14 August 2007

Ref: Ben Davidson Short Plat SP-07-111

BEN DAVIDSON REVISED 4 LOT SHORT PLAT

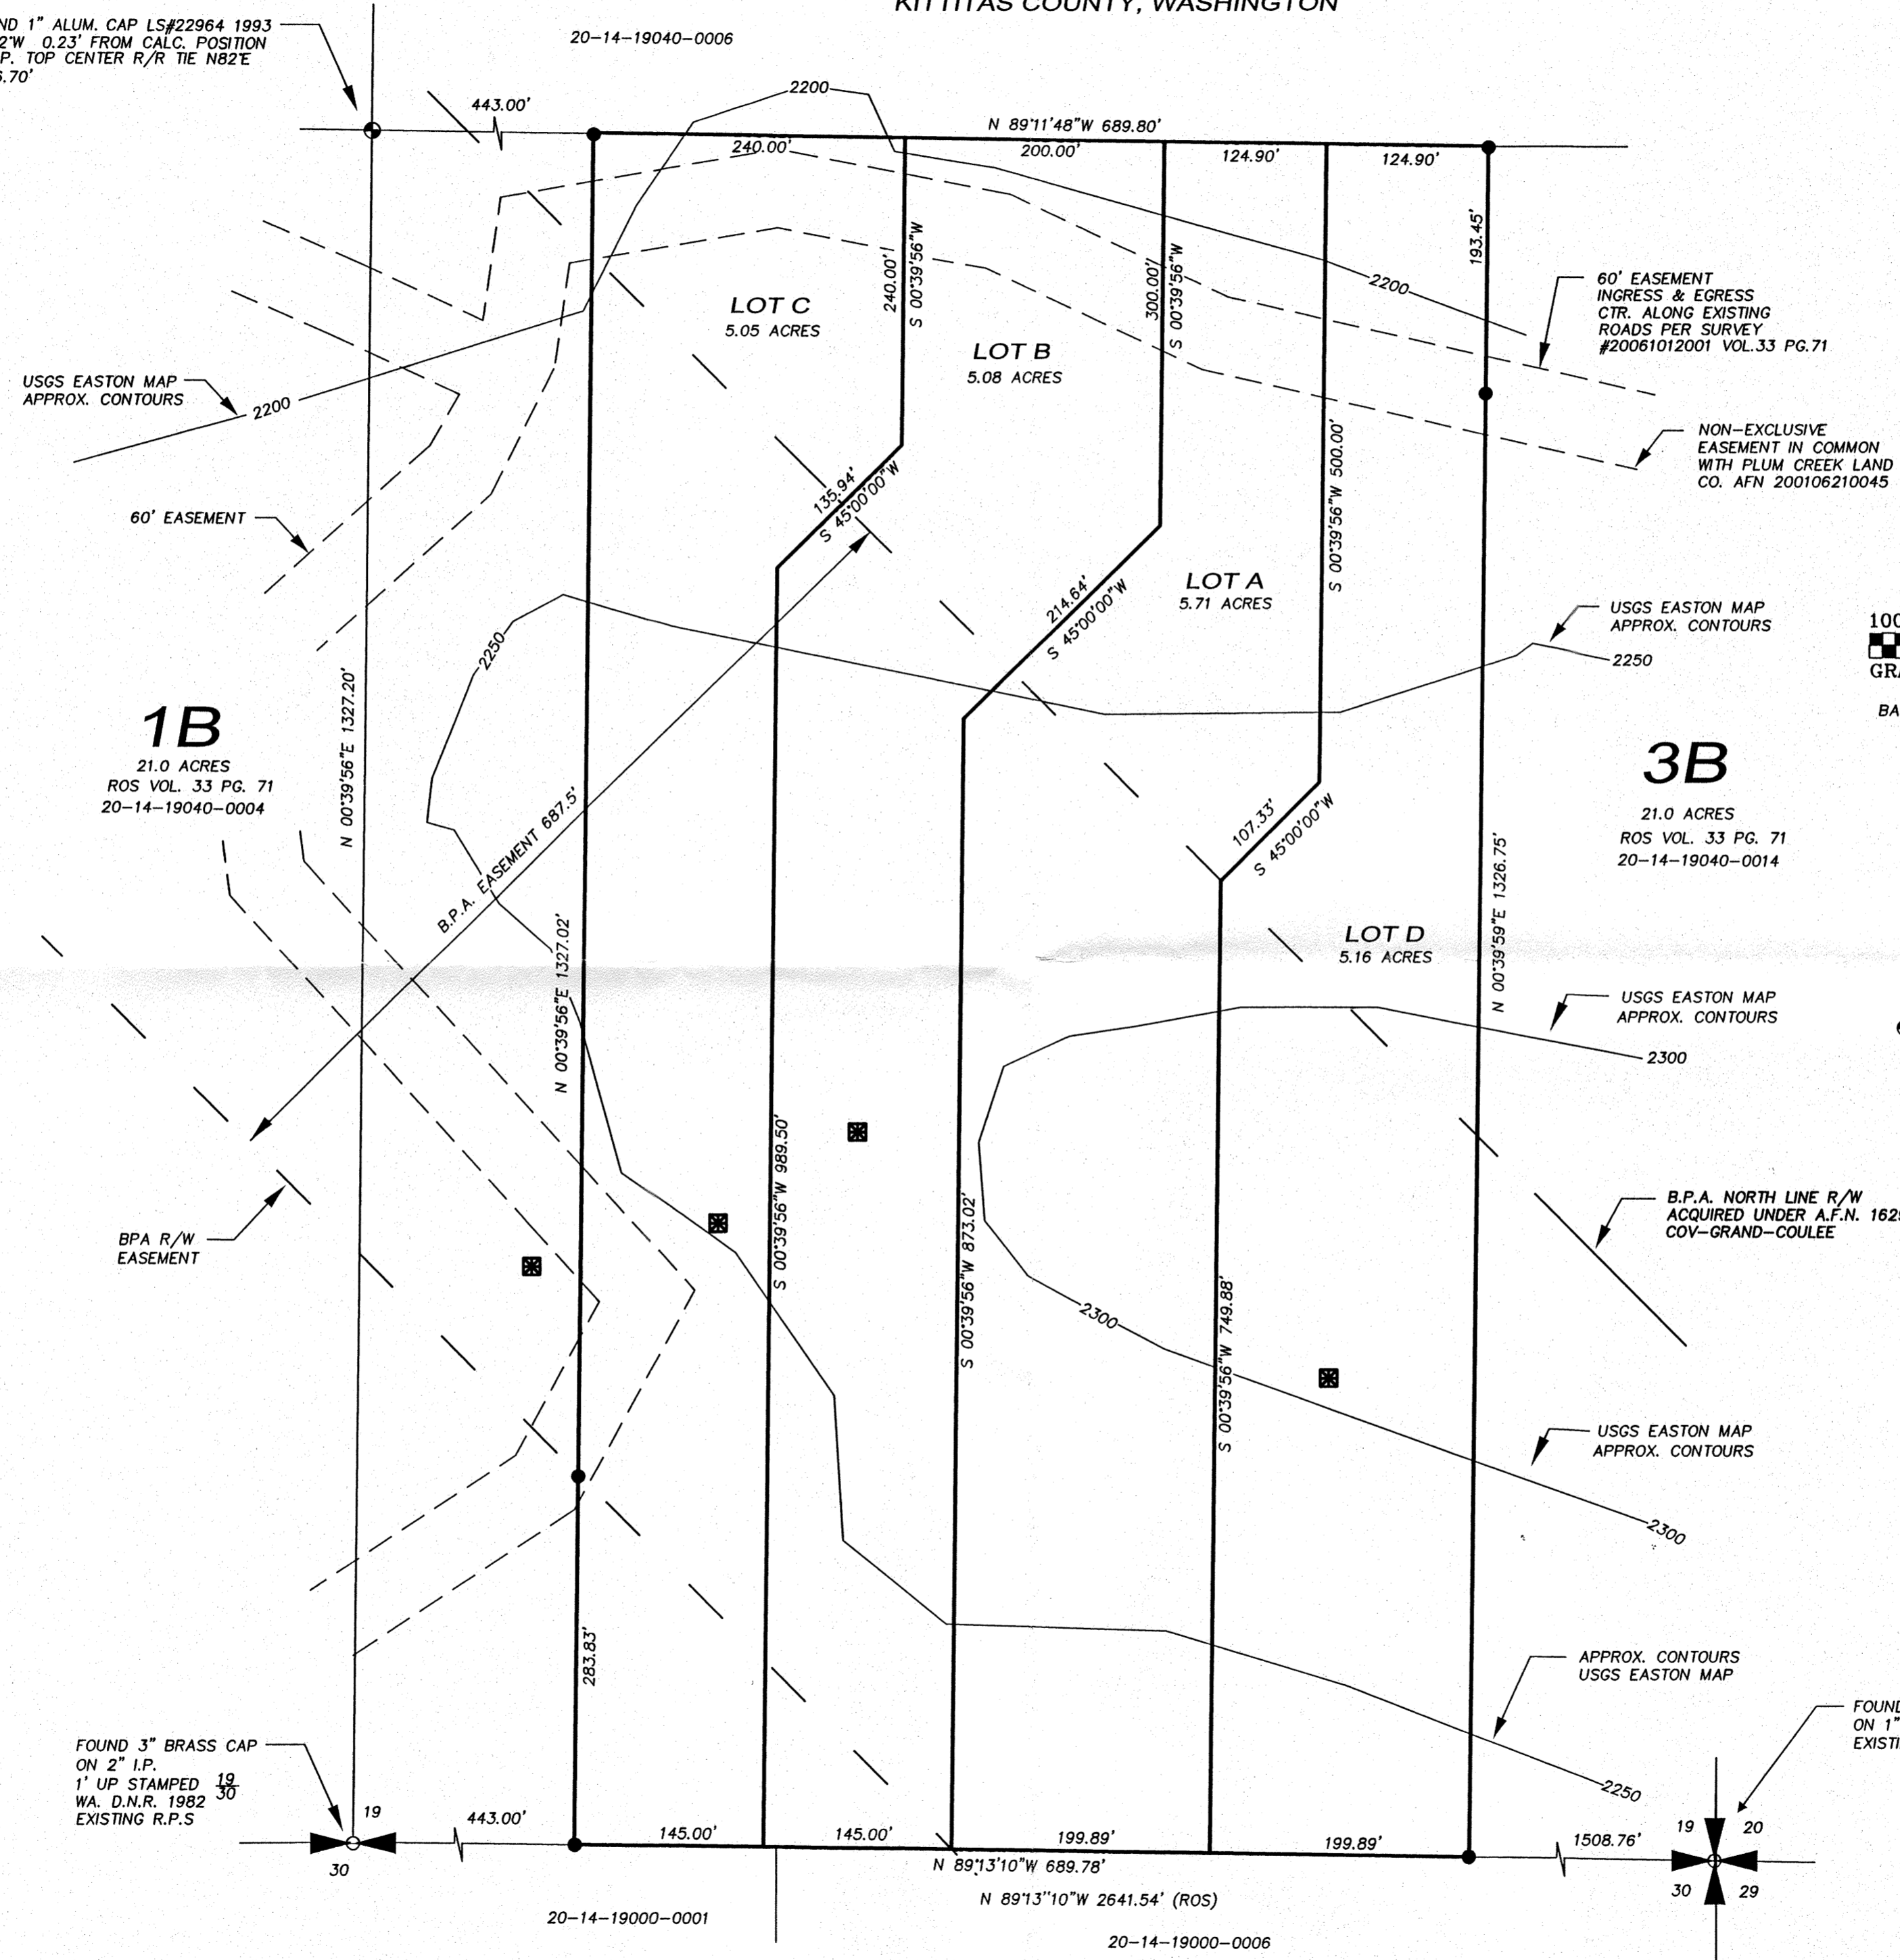
Now we finally get to the short plat map. **DUH!** Lot D, double **DUH!!** Who in their right mind would want a 40ft wide strip of land going nowhere? I realize there had to be some adjustments made, but since most of the land in all of these parcels is BPA Easement and the closest line to any of the proposed structures is the Grand Coulee/Ravensdale that carries three stacks of 500,000 Volts. If one of those goes to ground there is a 100-yard area that will kill anything in it faster than the devil could. I have had the pleasure of working with some of the BPA people that can educate the public on what can happen with high voltage power. They have engineered them to withstand most of what nature can dish out but they can't outmaneuver human stupidity.
